Online Comment

Application H01-0924-18
Location Land South: Moulton Chapel Road Cowbit Spalding
Proposal Development of 32 affordable dwellings

Name Angela Doherty
Address South Holland DC

Date Submitted 30-10-18
For/Against Comments

3 BED SEMI (893 sqft)

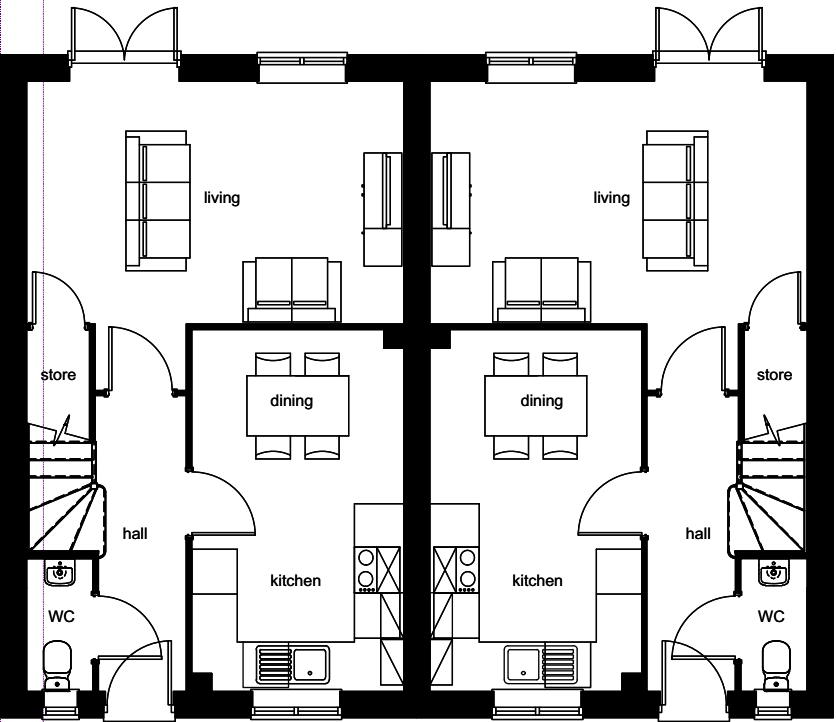
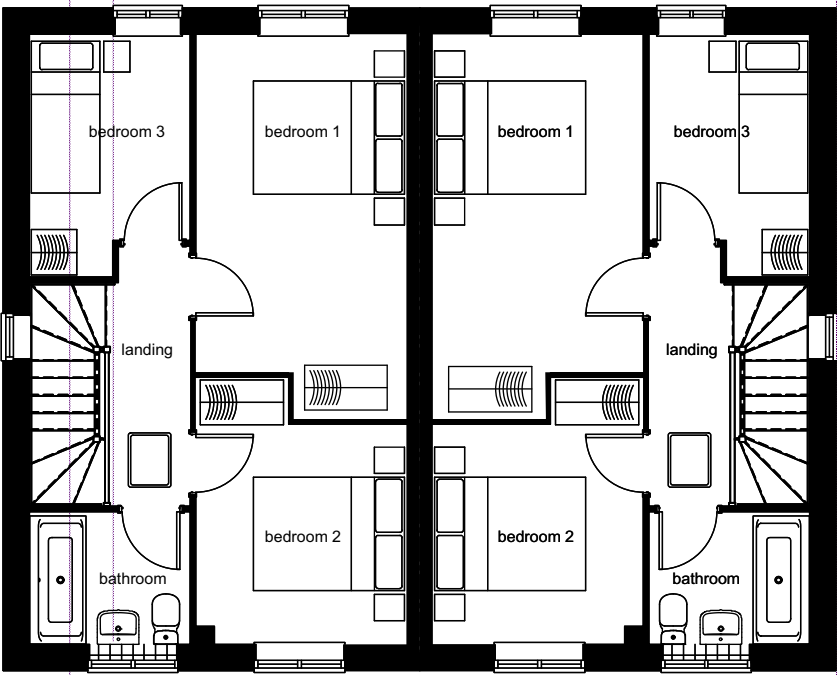
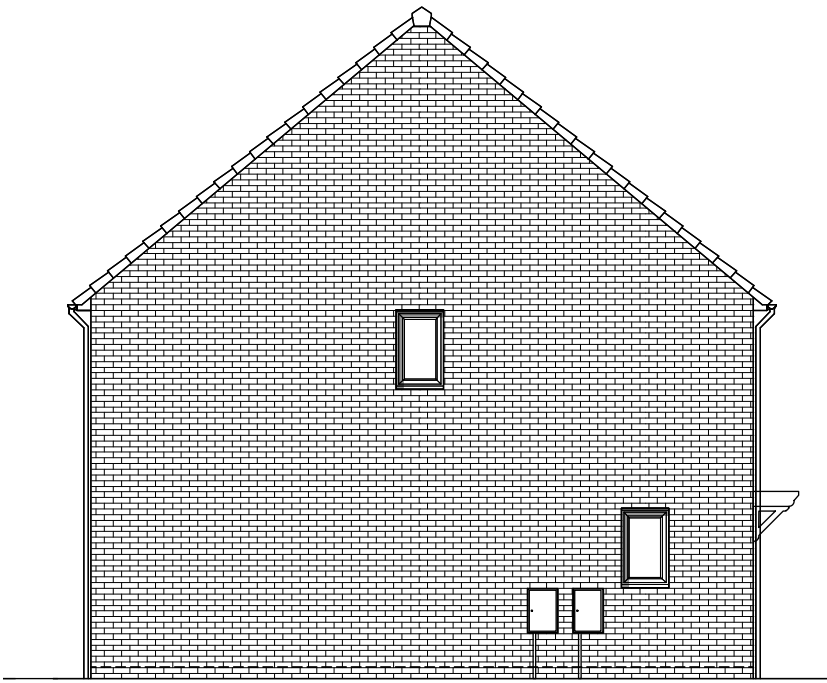
It would be preferable for the homes to be built to the 'National Space Standards'. As a minimum the affordable homes should be built to the former Housing Corporation Design and Quality standards which for this development would be at least:

1 beds 2 person 45sqm
2 beds 4 person 67sqm
3 bed 5 person 82sqm

2 BED BUNGALOW (614sqft)

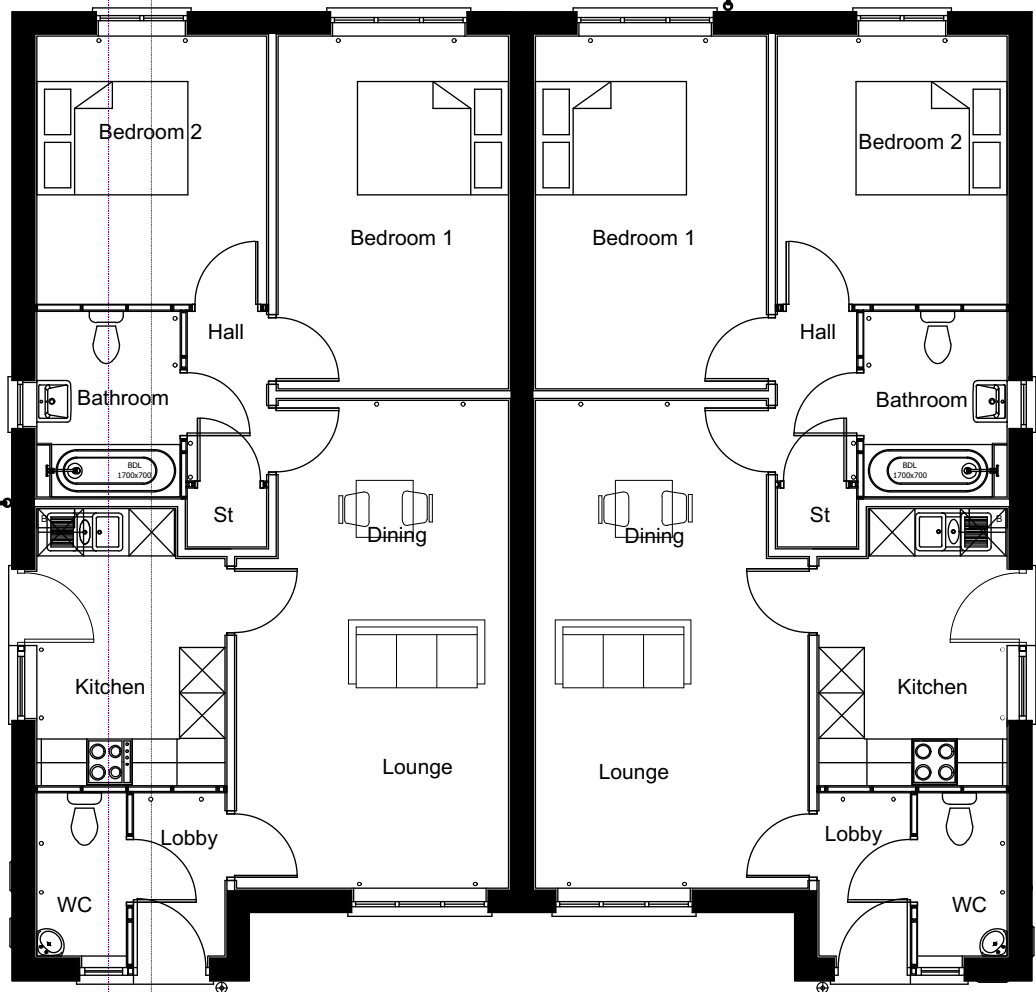
A proportion of the affordable home ownership products will also be available as bungalows. These can be available for households in need of bungalows attempting to access the home ownership market and can also meet the needs of existing home owners in need of bungalows that are attempting to downsize but do not have enough equity to purchase on the open market.
